**MIKE CAUSEY**  
INSURANCE COMMISSIONER & STATE FIRE MARSHAL

October 21, 2022

BCOM 2302-0007

**RE: The Springs of Ballentine  
Hectors Creek, NC – Harnett County**

## LIFE SAFETY PLAN

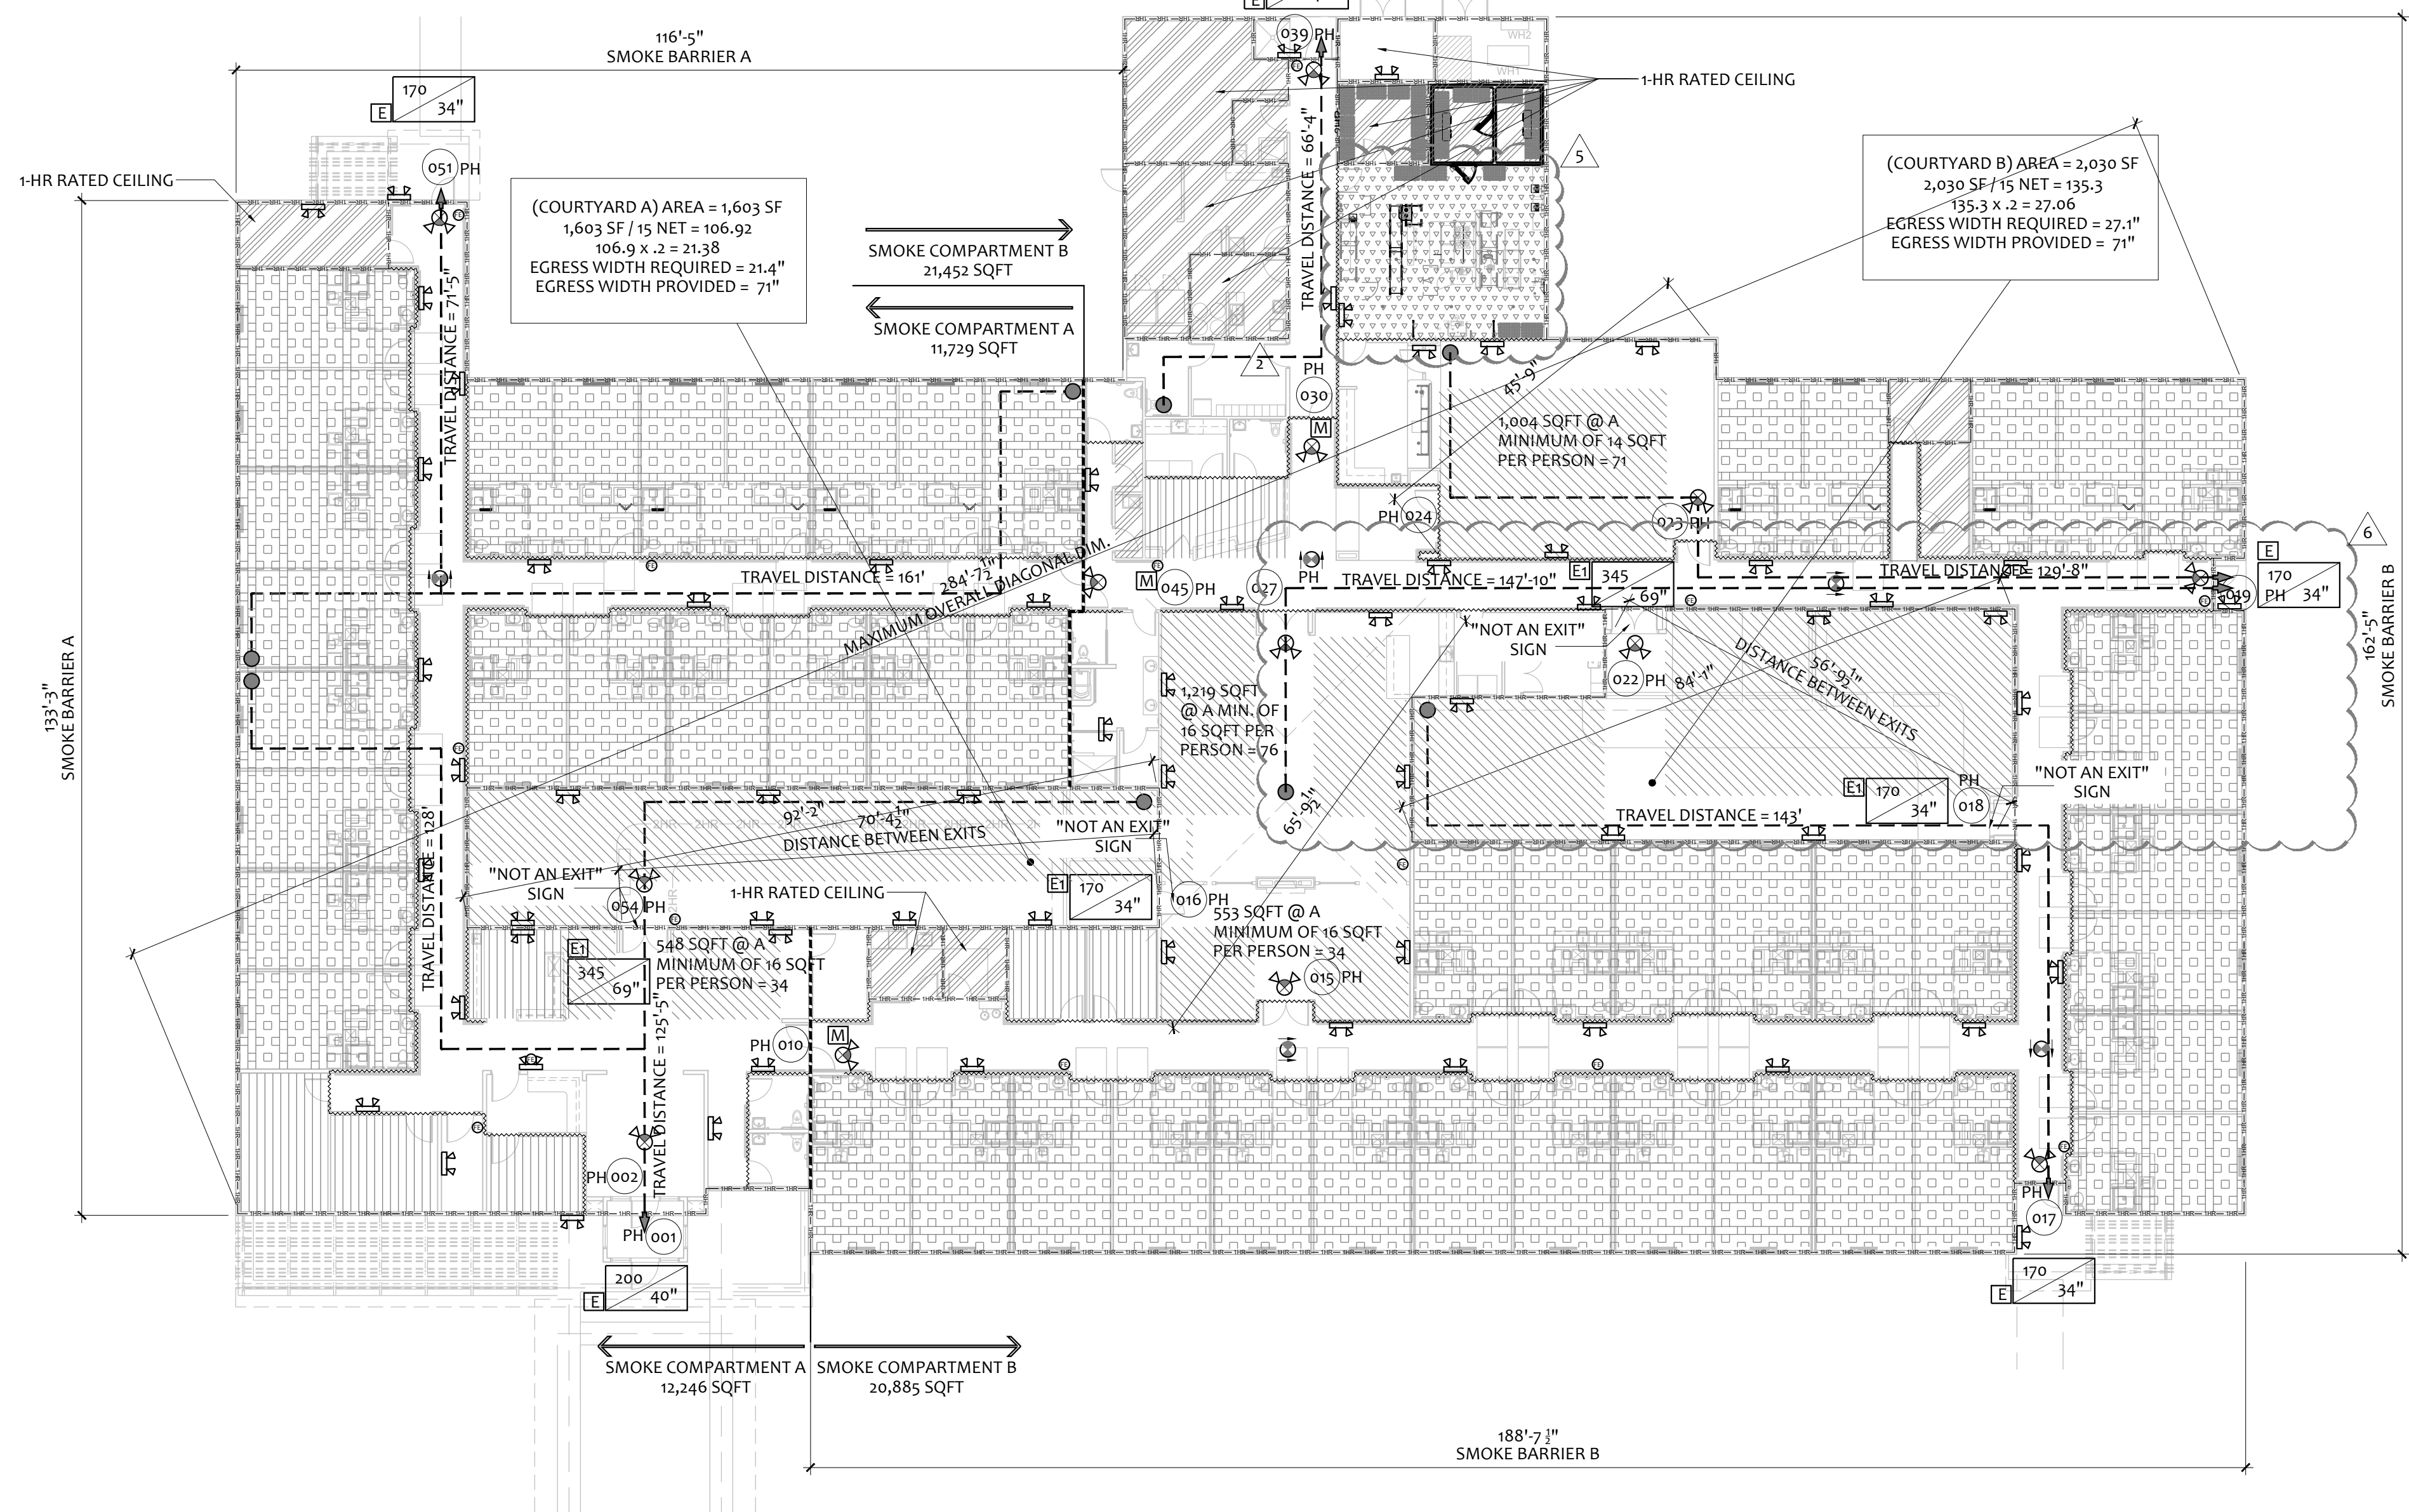
10. Page A002 – Life Safety Summary Chart, Area square footage for Assembly and Kitchen doesn't match the square footages listed in the Code Review section.

11. Page A002 – the Minimum Egress Width calculation doesn't add up for the required egress width line. The maximum number of people doesn't match the Total Occupancy provided.

12. Page A002 – Life Safety Plan Note #4, this note states that ratings of structural elements shall be found on Page A000. Unable to locate this information on Page A000.

13. Page A002 – Life Safety Plan Note #9, this note states that assembly room occupancy loads shall be posted per NCPC 1004.3. Confirm code reference.
14. Page A002 – Exterior egress calculations do not match for all five exit doors for the egress capacity factor of 0.2. All doors are low on capacity shown.

15. Page A002 – Courtyard Area A, square footage and occupant load numbers do not appear accurate as if some of the calculations were copied from Area B. Please update.

16. Page A002 – Guest rooms, the "travel lines" shown are not drawn correctly: The Code contemplates right angle (not 45 or 60 degree) turns since the former produces the most conservative (i.e., longest) Travel Distance To An Exit; please revise the Plans accordingly to extend to most remote area of room for most accurate distance.

17. Page A002 – Unable to locate the door location for 002. The door symbol is in the middle of the front lobby but no door could be identified.
18. Page A002 – Data Room 104, fire extinguisher required inside this room if actual computer equipment is stored inside. 2018 NC Fire Code, section 906.1 #6.

19. Life Safety Sheet – Provide full building diagonal length. Provide similar dimensions for any assembly rooms/areas/courtyards.
20. Life Safety Sheet – Identify all doors requiring panic hardware including Electric Room doors if they have electrical equipment meeting or exceeding 800 amps. Please add "PH" symbols or similar identifier for these doors.

21. Life Safety Sheet – All interior and exterior emergency lights shall be shown on the Life Safety Plan.
22. Submit manufacturers signed, sealed and dated pre-engineered truss drawings including layout.

**A201**  
 OVERALL FLOOR PLAN

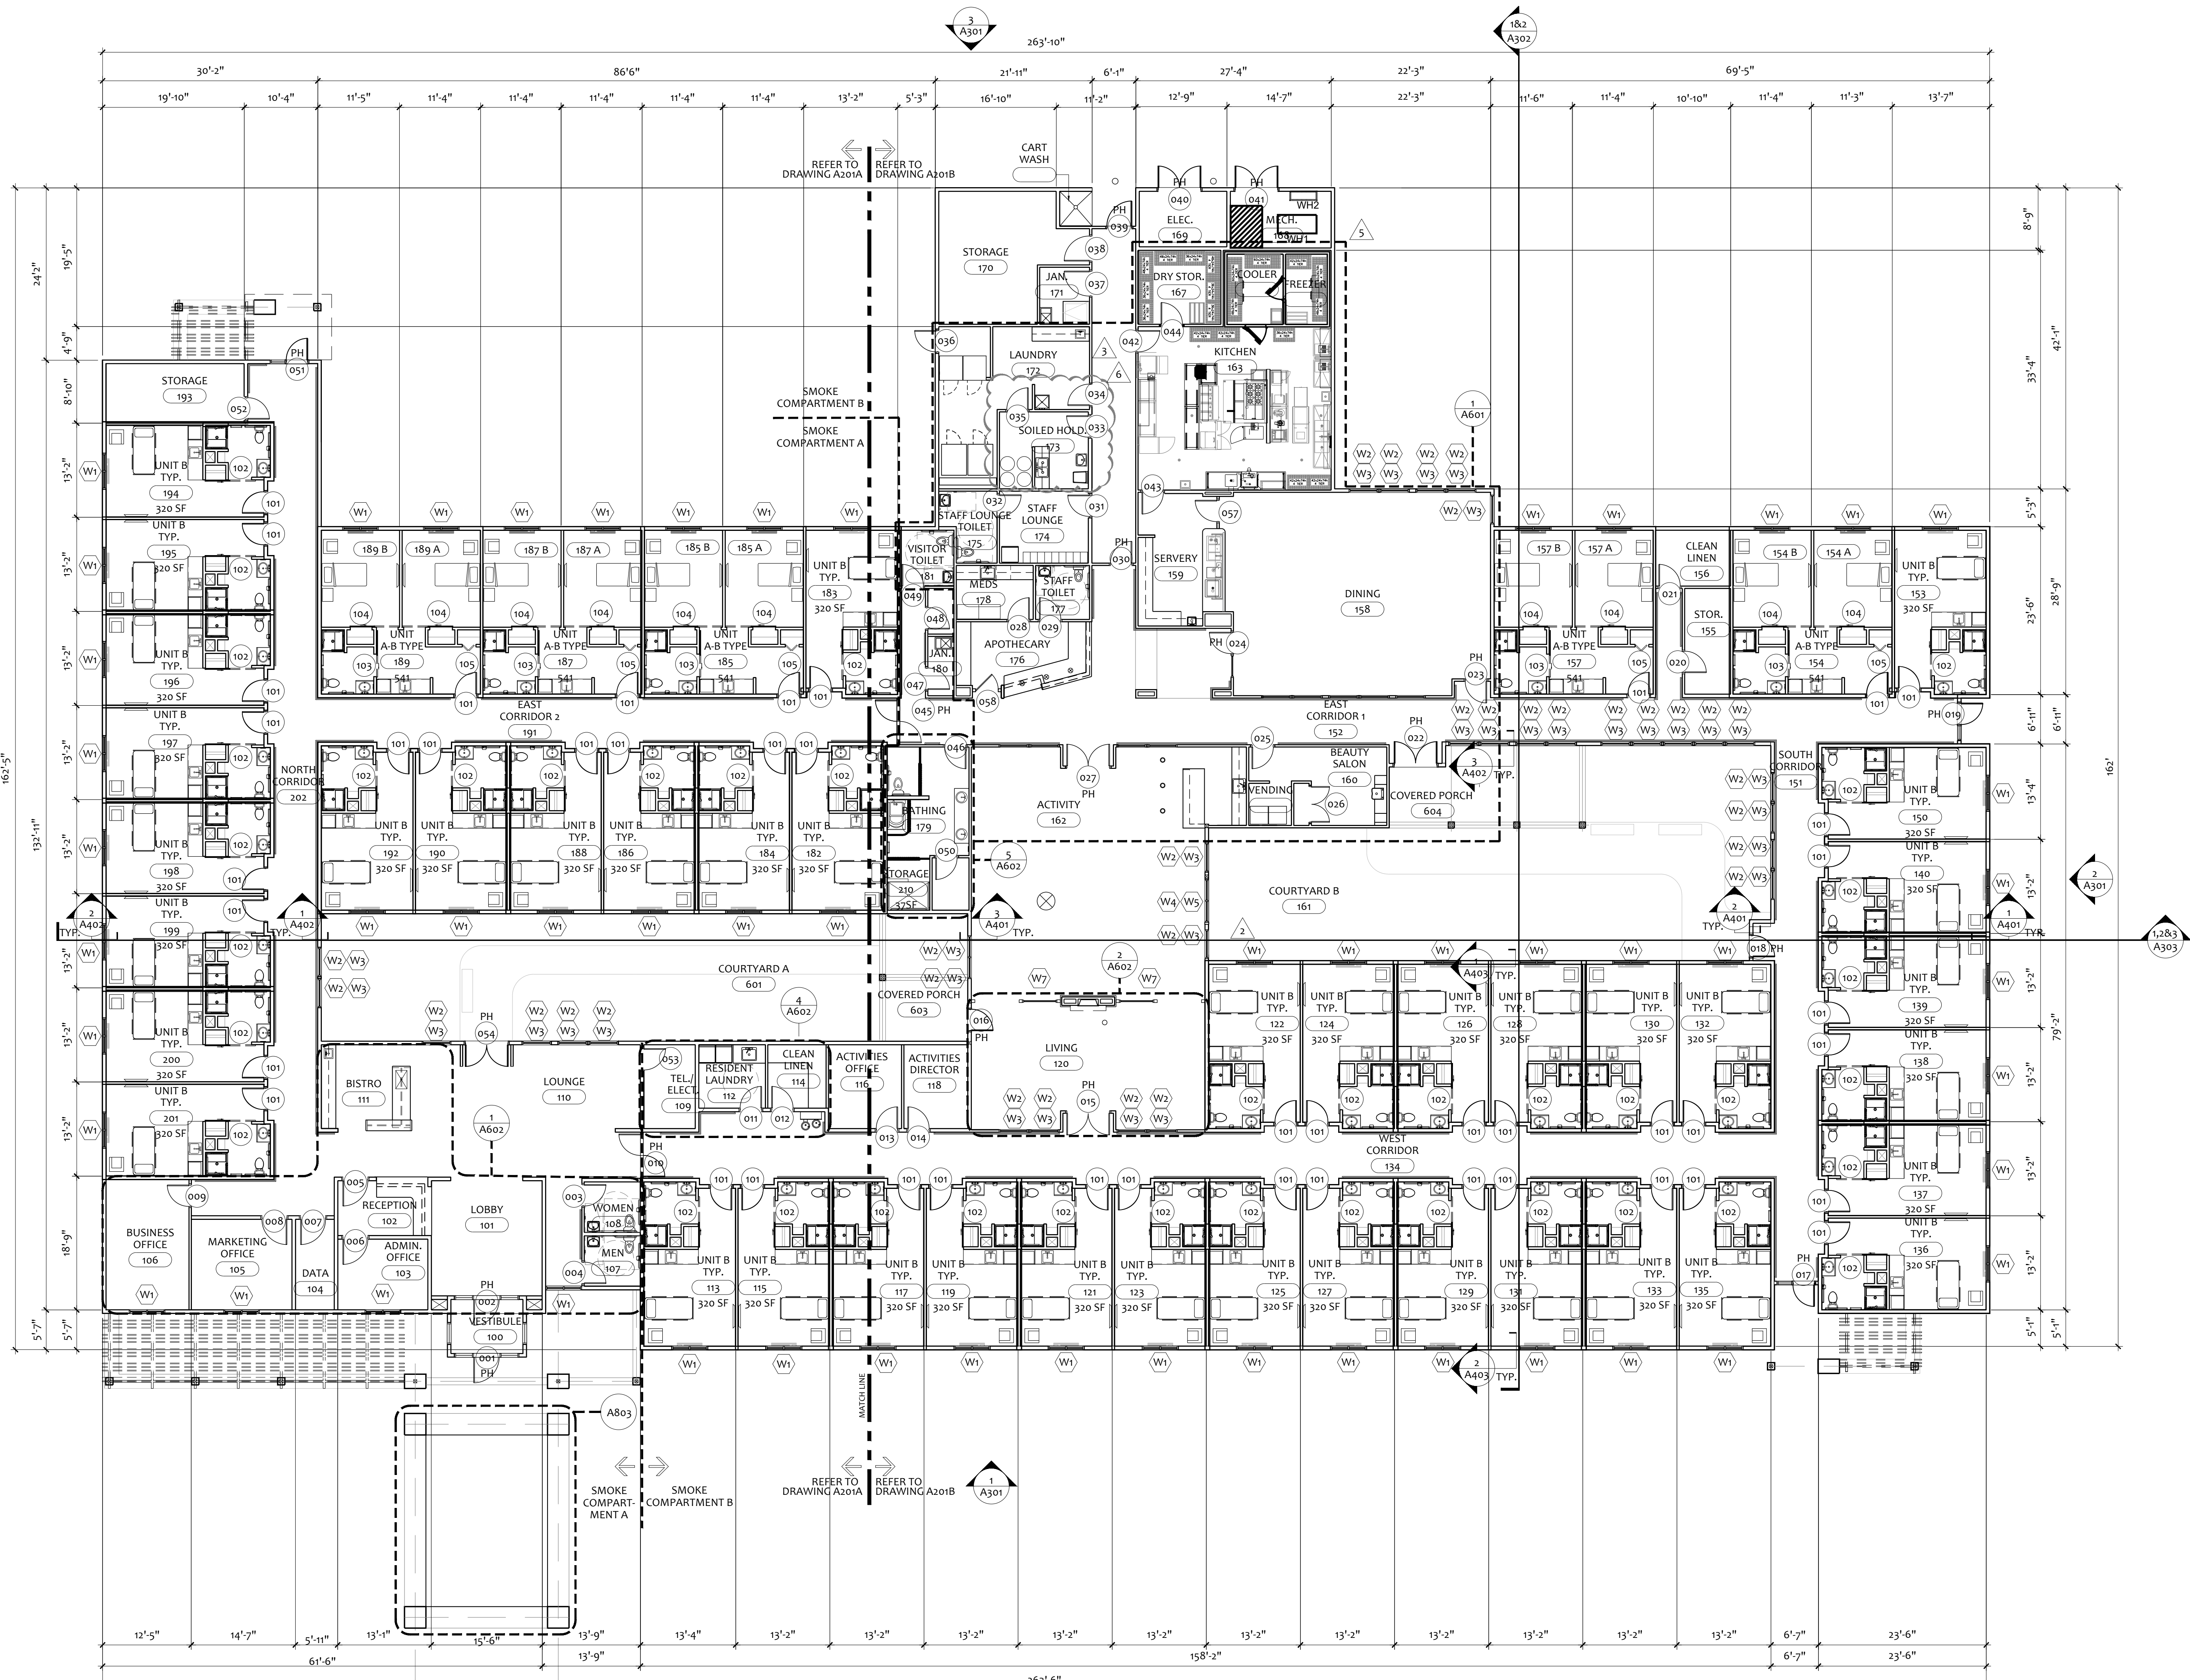
27. Page A701 – Doors 033, 034, 037, 038 and 053 are all in a one hour rated wall and shall be fire rated accordingly.
28. Page A201 – Doors 025 and 042 shown at Beauty and Kitchen respectively are listed to have panic hardware but swings the incorrect direction for egress.
